**KIRKLEES METROPOLITAN COUNCIL
INVESTMENT & REGENERATION SERVICE**

**DELEGATED DECISION FOR DISCHARGE OF CONDITION A.4 -
NOTIFICATION OF A PROPOSED ENLARGEMENT TO DWELLINGHOUSE**

Reference no.	2020/HH/94127/E
Site Address	53, Thorncliffe Road, Staincliffe, Batley, WF17 7AS
Description	The proposal is for erection of single storey rear extension. The extension projects 6.3m beyond the rear wall of the original dwellinghouse. The maximum height of the extension is 4m, the height of the eaves of the extension is 4m
Recommending Officer	Tom Hunt

GROUND FLOOR

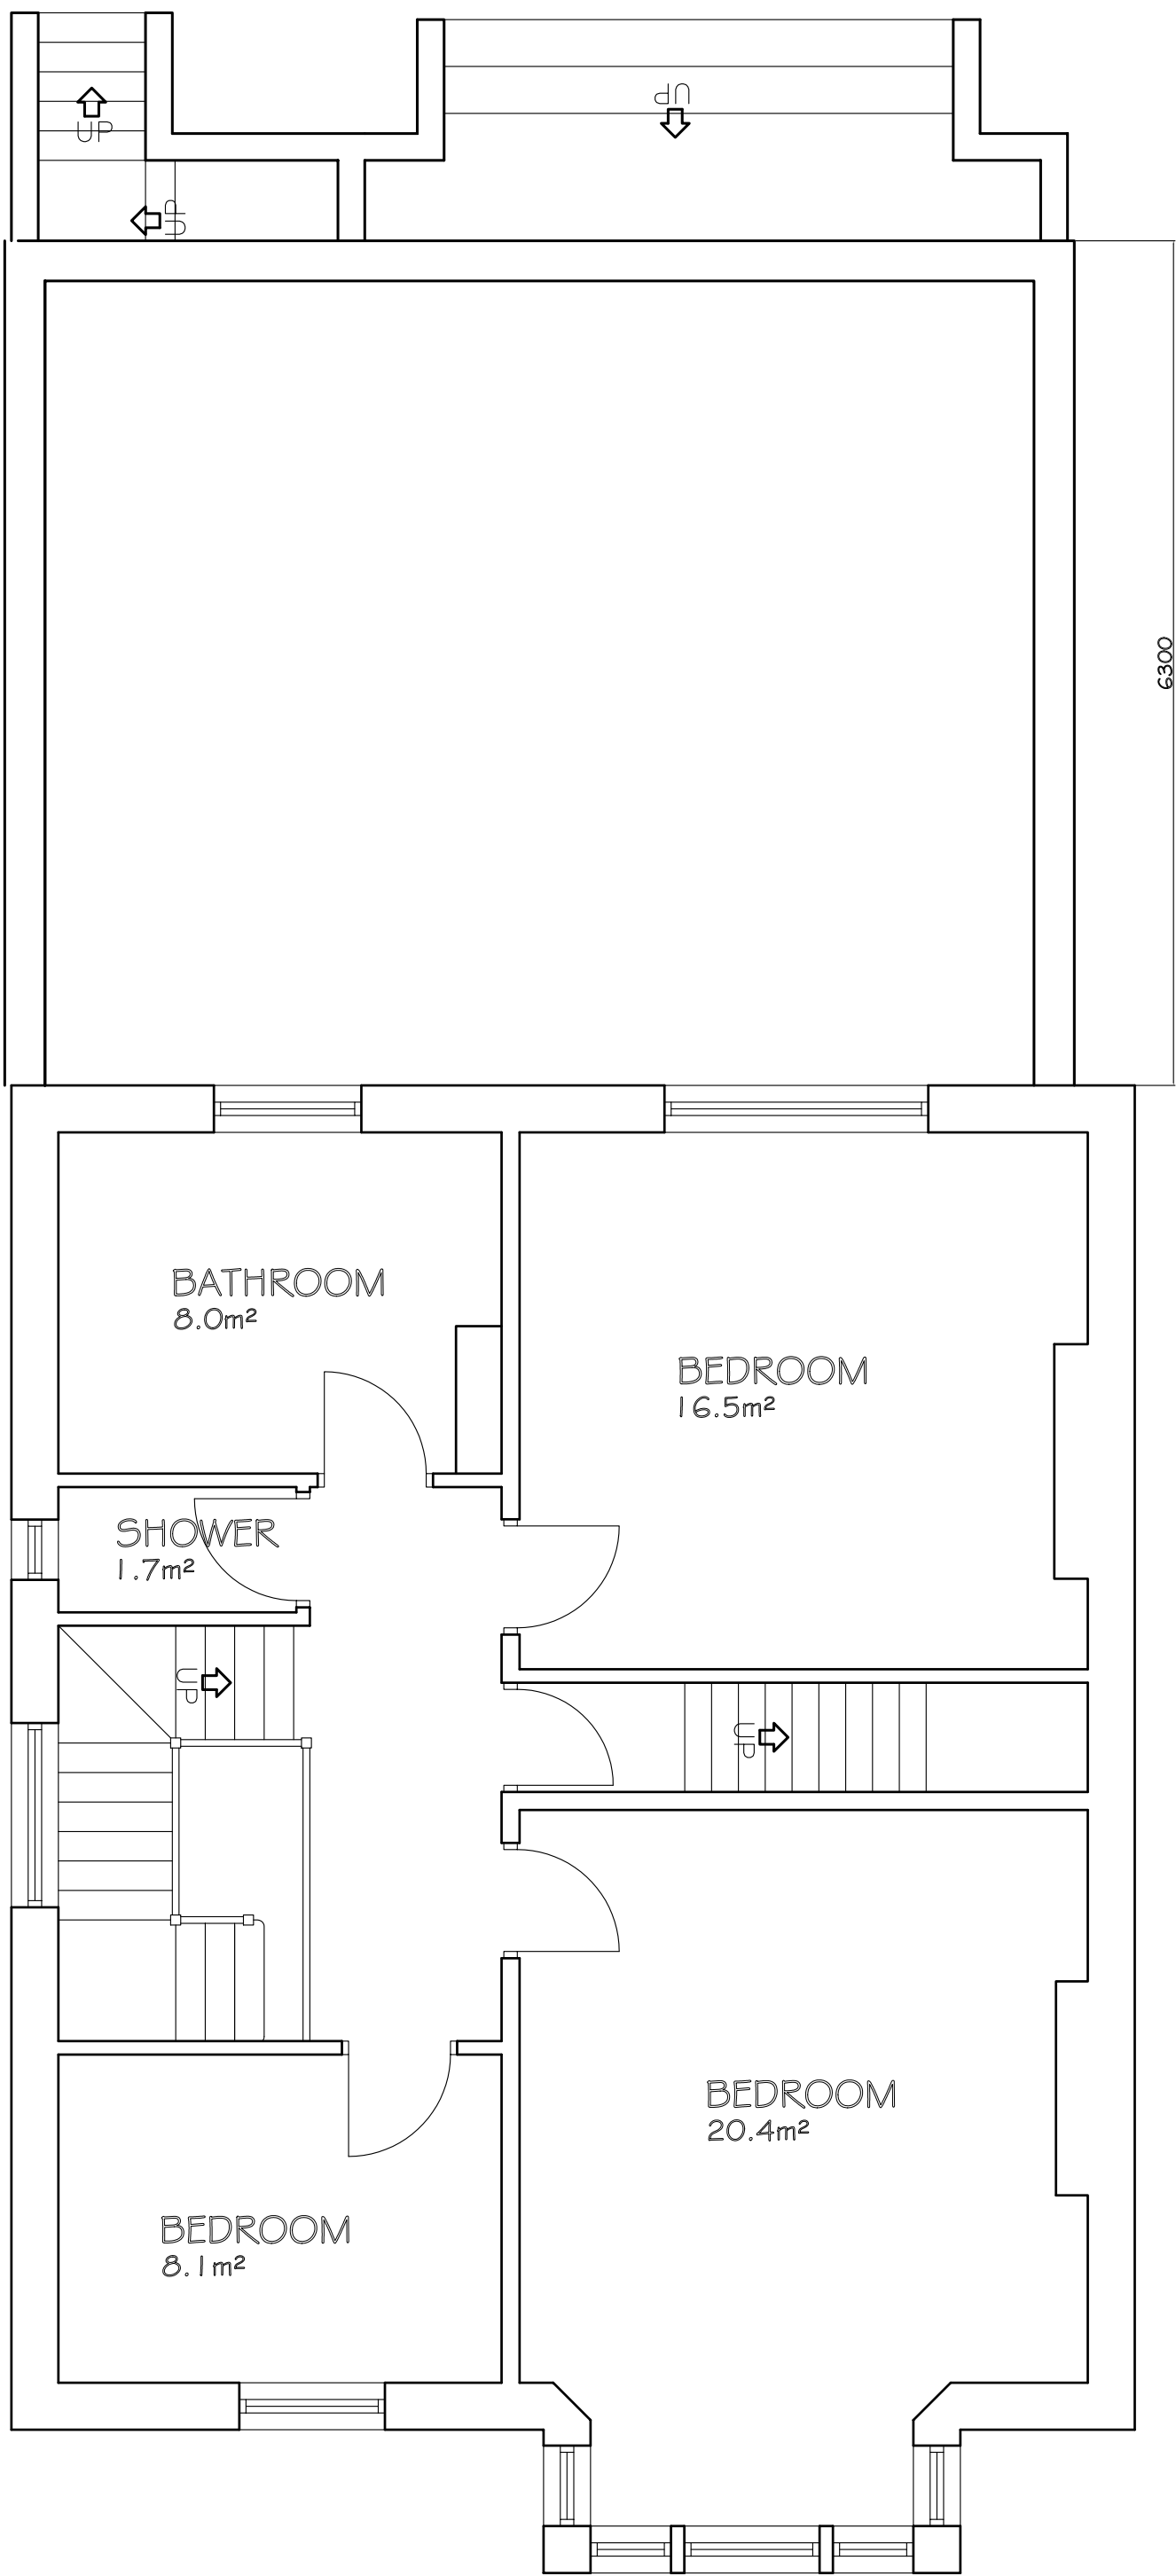
The proposal is for erection of semi subterranean two storey rear extension. The extension projects 6.3m beyond the rear wall of the original dwellinghouse. The maximum height of the extension is 4m, the height of the eaves of the extension is 4m.

The extension is 4m from the ground level however it has a lower ground storey which would mean a maximum height of 5.67m approximately.

The proposal would have a projection of 6.3m from the rear wall of the original dwellinghouse. The proposal therefore fails to meet the criteria of the General Permitted Development Order 2015, Schedule 2, Part 1, Class A paragraph h).

DRAWING TITLE  
PROPOSED SECTIONS

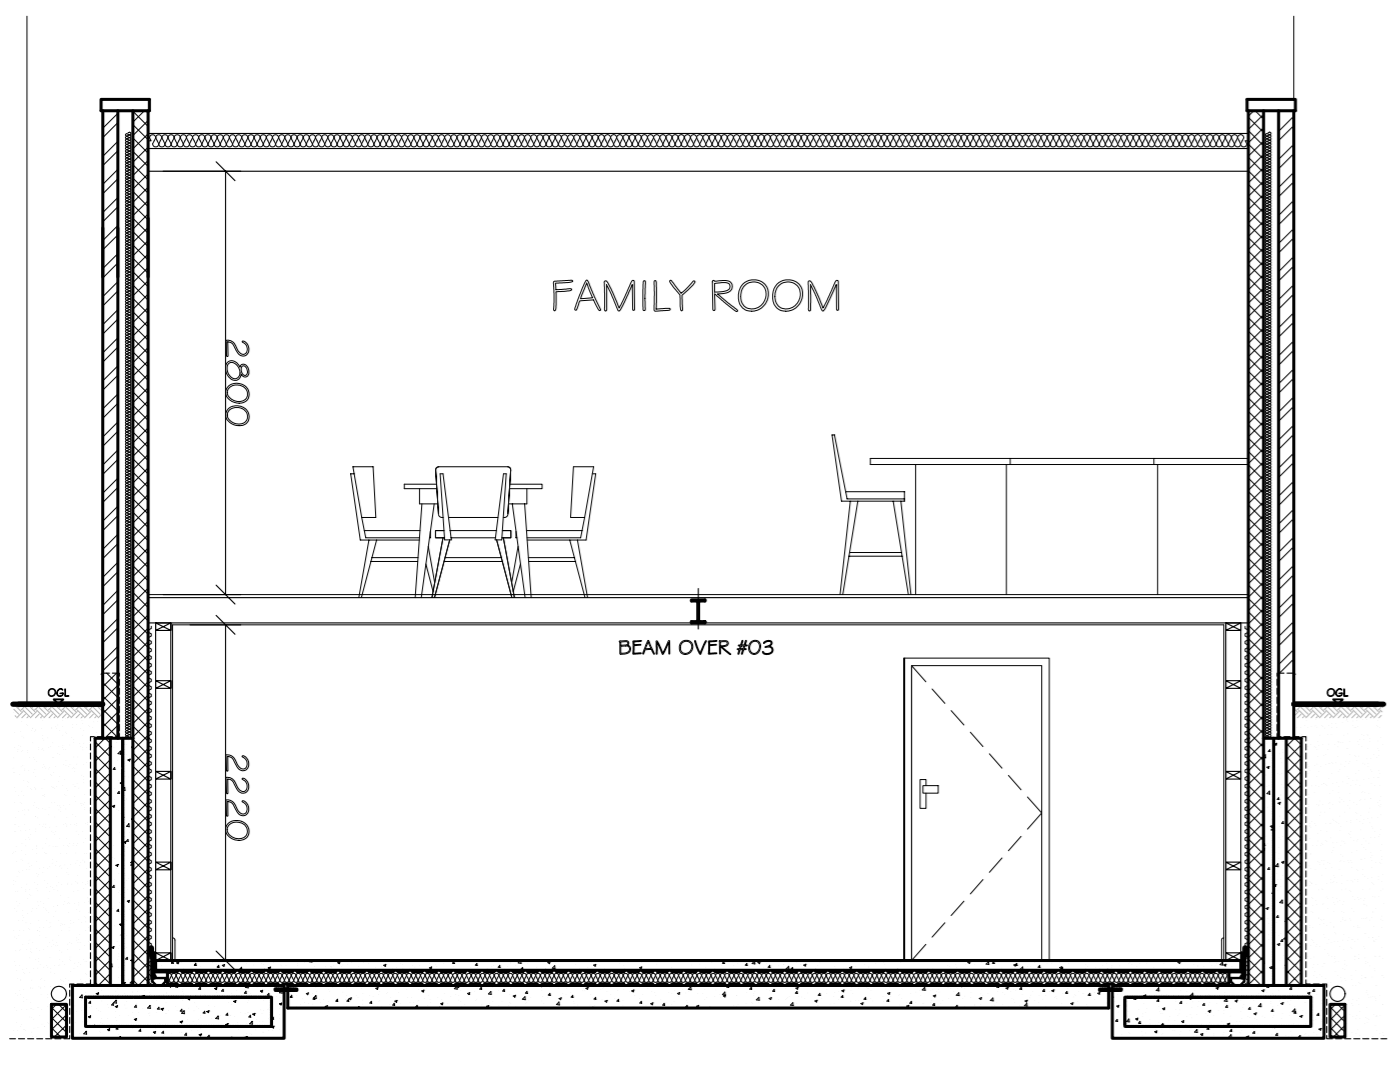
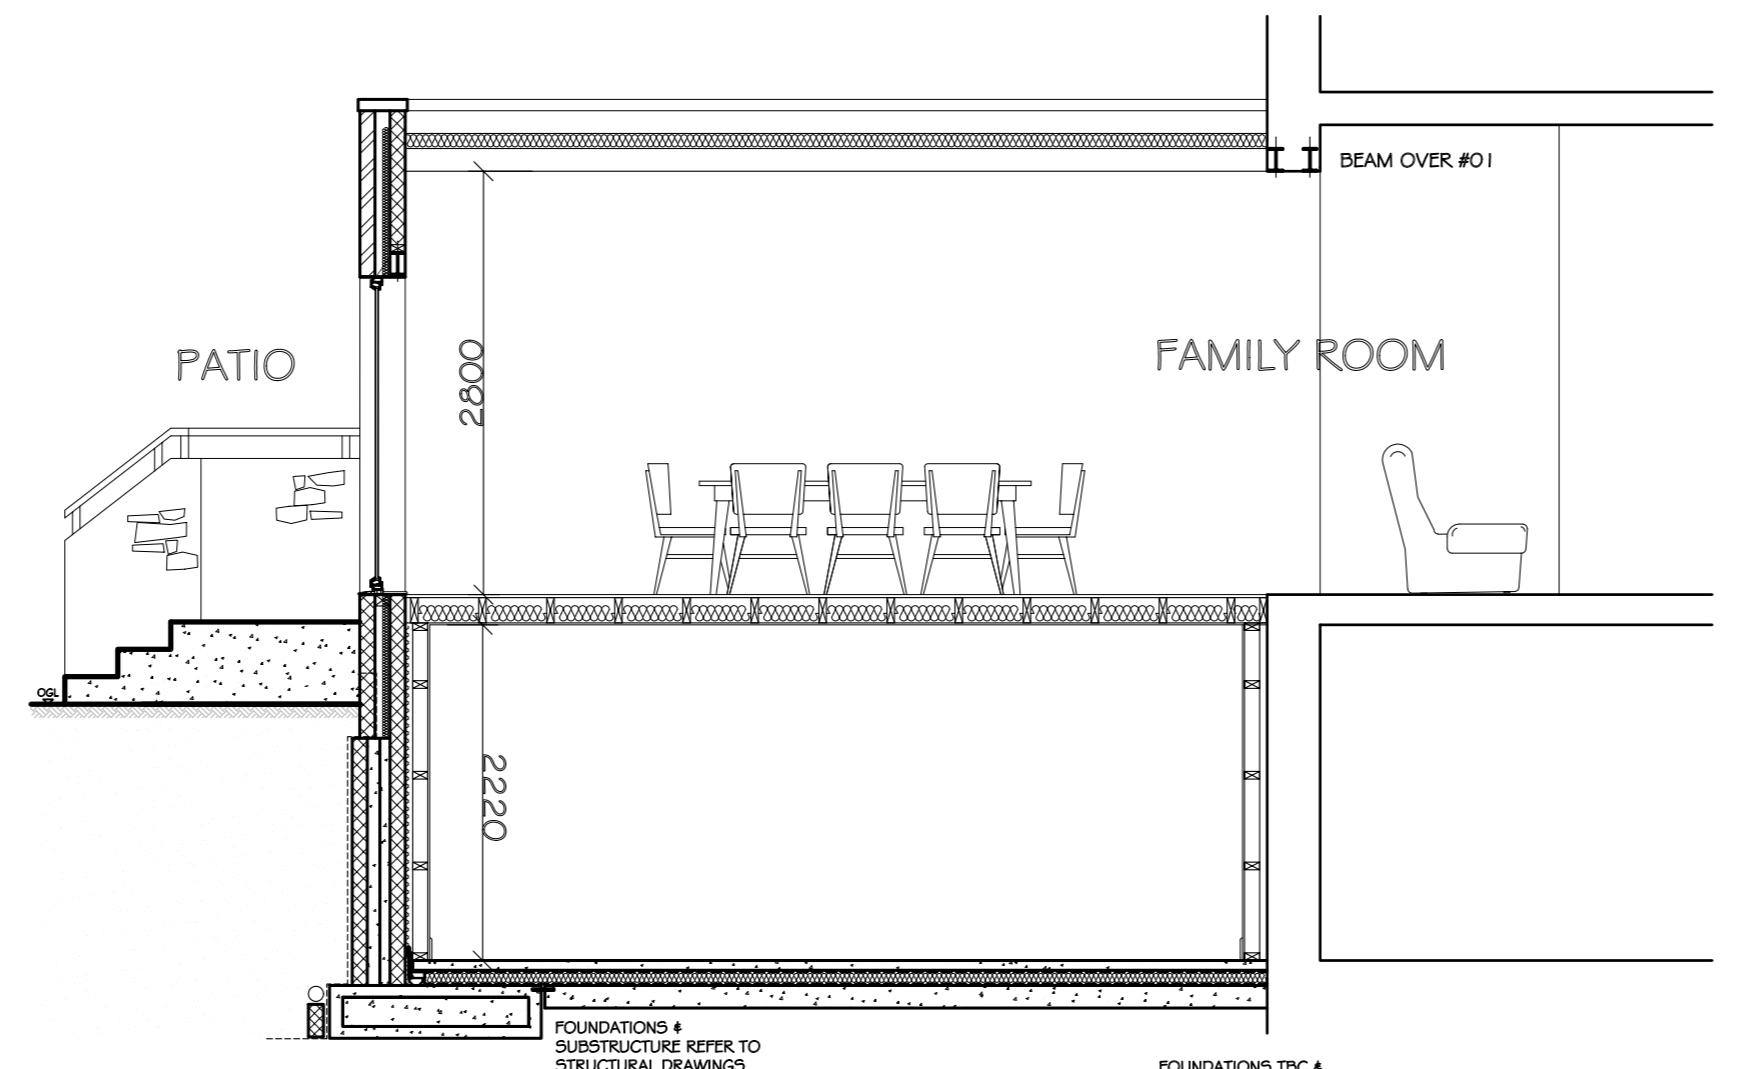
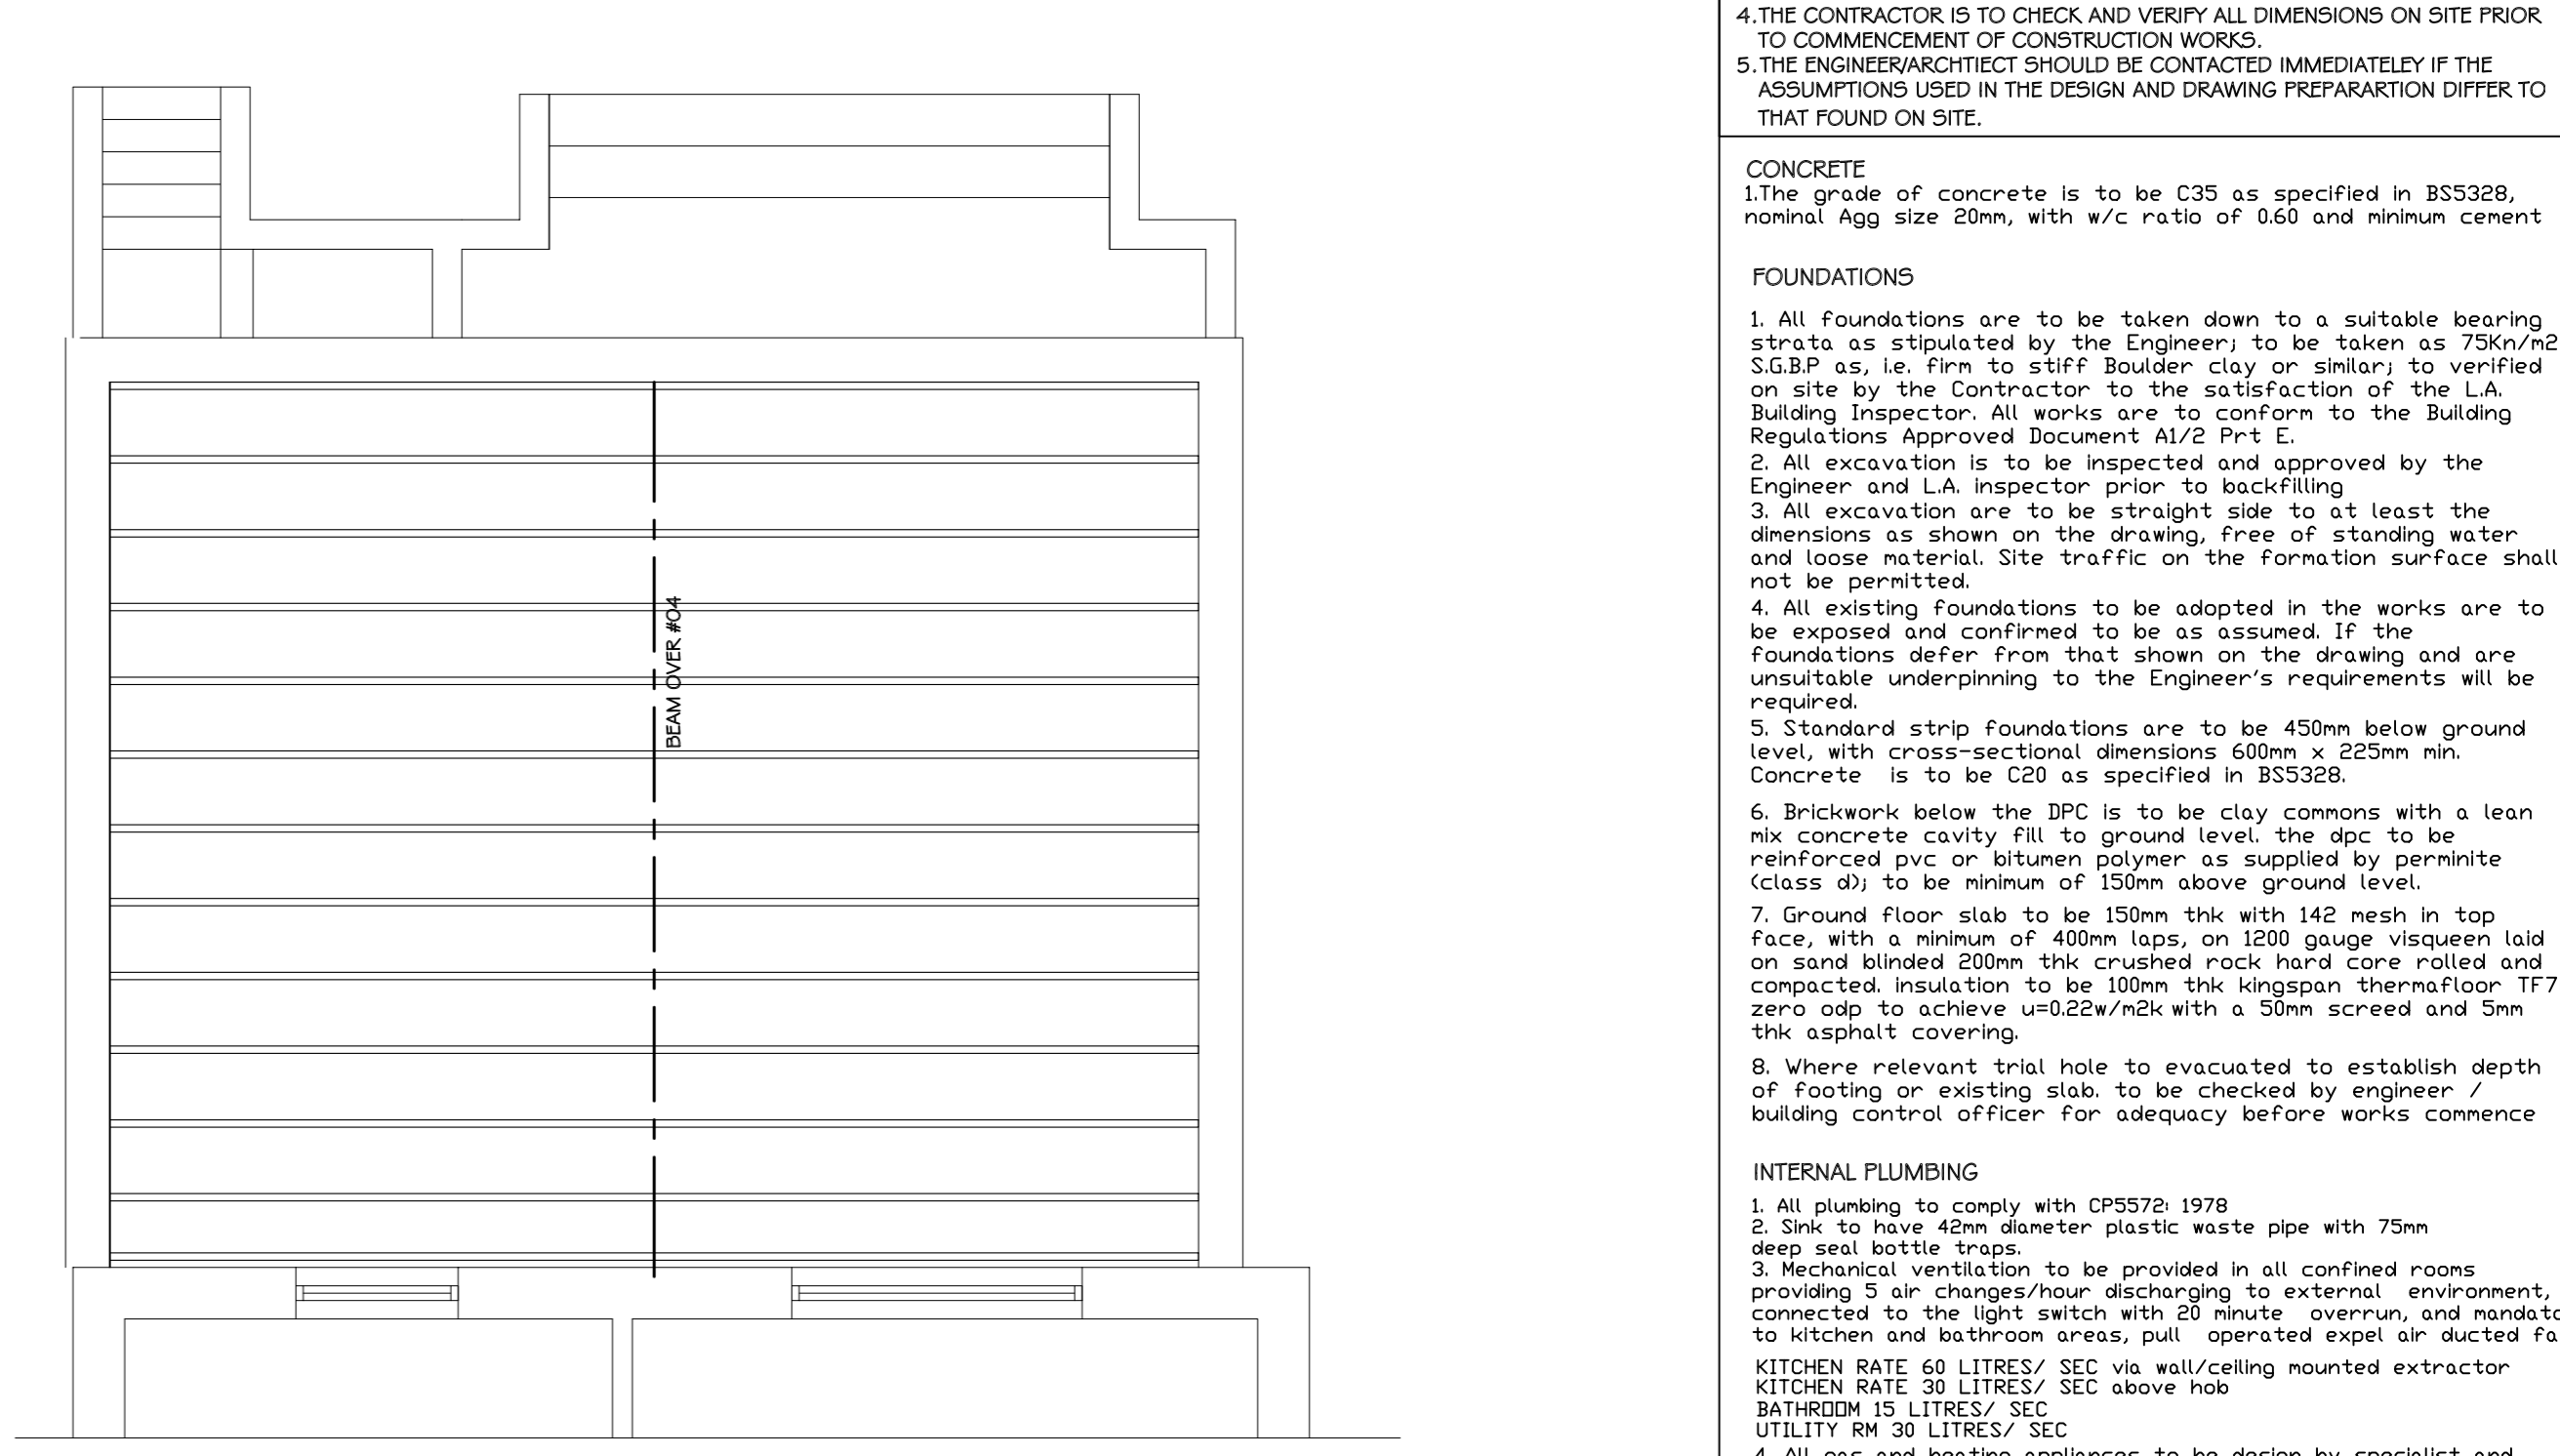
Where any part of a proposed extension to a house is within 2 metres of the boundary of its curtilage, then the maximum height of the eaves that is allowed for the proposal is 3 metres. The proposed extension would be 4m height above ground level and therefore the proposal fails to meet the criteria

of the General Permitted Development Order 2015, Schedule 2, Part 1, Class A paragraph i).
